Sani-clean Distributor Building

TO: Kandice S. Talbot – Planner
FROM: Jim Seymour – Development Review Coordinator, Sebago Technics, Inc.
RE: Revised Plan Review: Sani-Clean Distributors Building - 470 Riverside St.
DATE: March 16, 2004

Sebago Technics has reviewed the revisions of the Major Site Plan/Site Location of Development application and supporting documentation dated 3/5/03 for the proposed development of Sani Clean Distributors at the site of the former Butler Commercial Subdivision located at 470 Riverside Street in the City of Portland. We respectfully offer our revised comments (*in bold italics*) in outline format:

LEVEL LIP SPREADER
 NOT TO SCALE

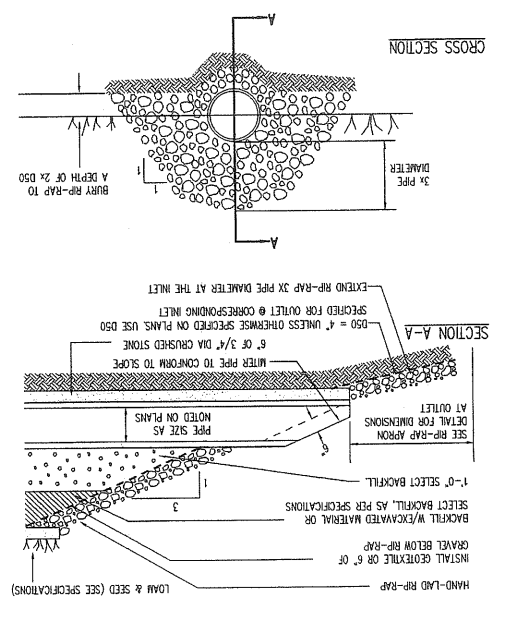
B. The level lipped spreader on the south side of the building appears to discharge over a very steep slope. Alternate locations should be reviewed. *Accepted and approved.*

C. The selected level-lipped spreader location appears to be just up gradient of a natural channel according to the topographic data. The spreader shall be shifted or relocated to discourage channeling of the discharged flow. *Accepted and approved.*

SITE LAYOUT AND UTILITIES PLAN

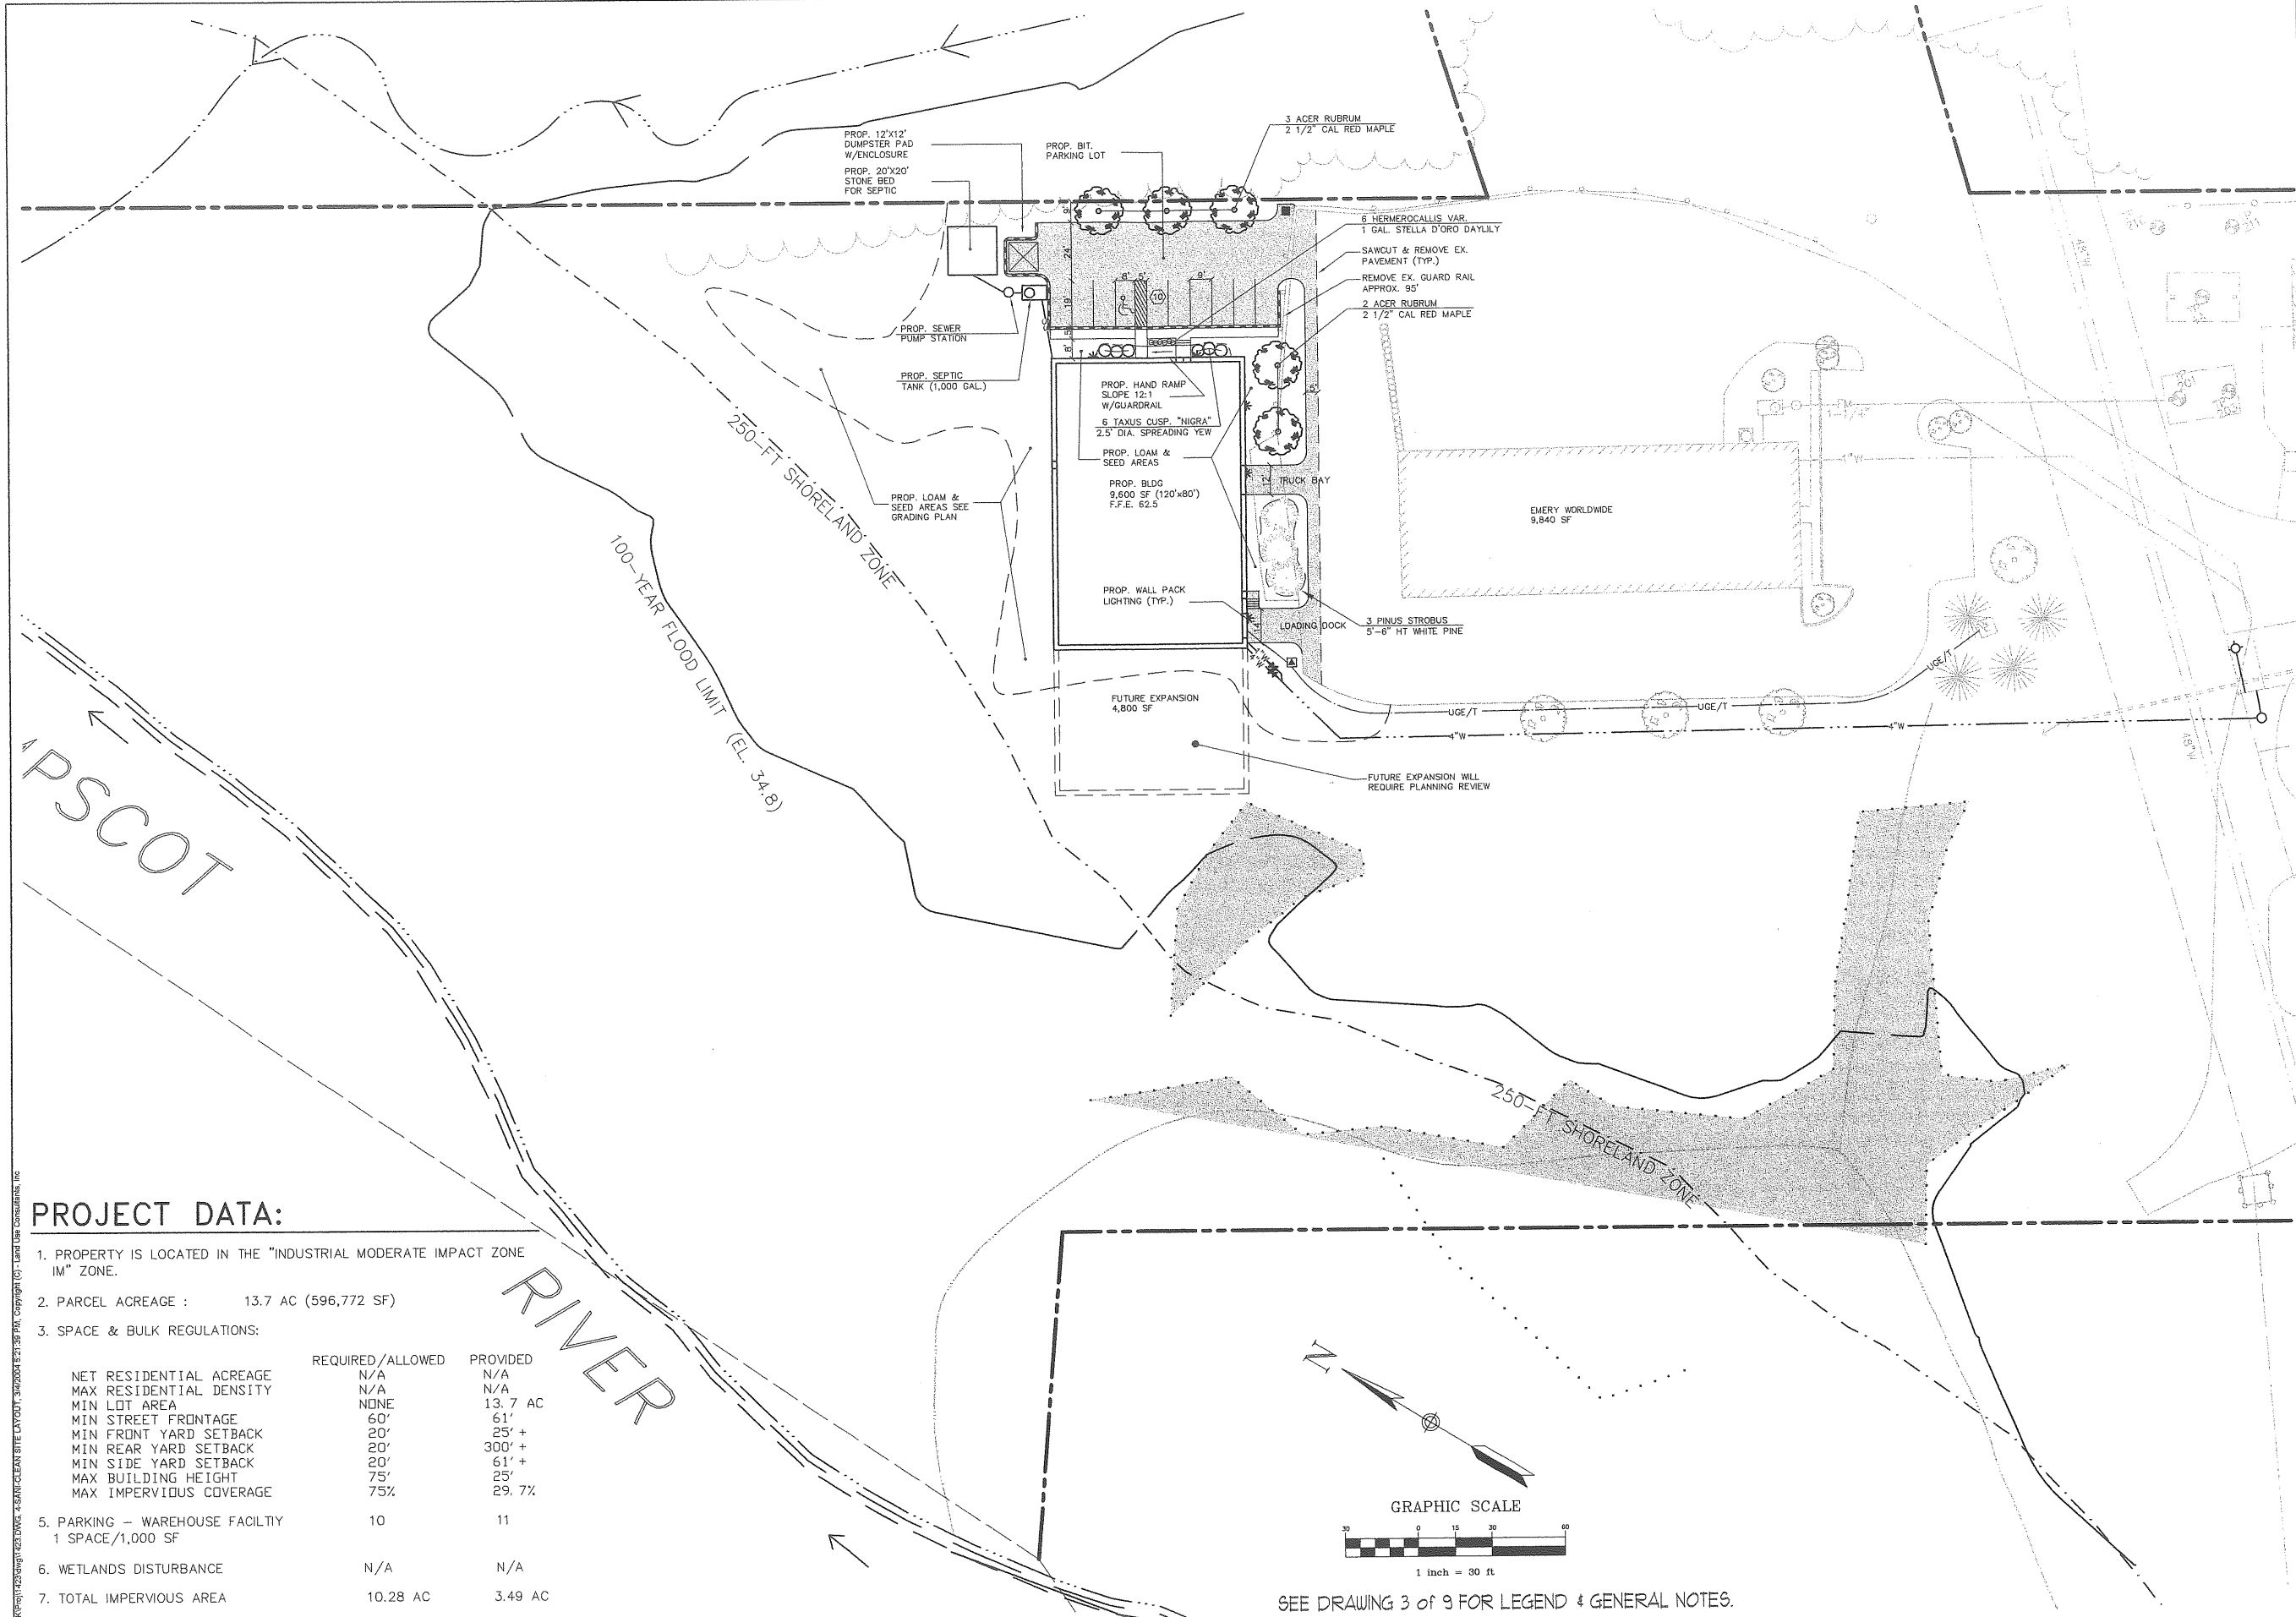
A. The location of the septic system appears close to the property line and steep embankment. Give the soils and slopes it may be easier to install if the leachfield followed the contours 57 and 58. Our concern is with the fill slope on the northeast side. *Accepted and approved.*

A. The applicant needs to include a detail of how the existing access road will butt against the proposed widening. *Accepted and approved.*

B. For the purposes of access, we feel that the Catch Basin #1 shall be relocated from the property line and edge of slope and placed within the parking lot associated with the facility and will provide the necessary room to properly construct, without impact to the abutter's property. The location in the parking lot will also continue to collect and function in the winter when snow will cover the currently proposed location. *Accepted and approved.*
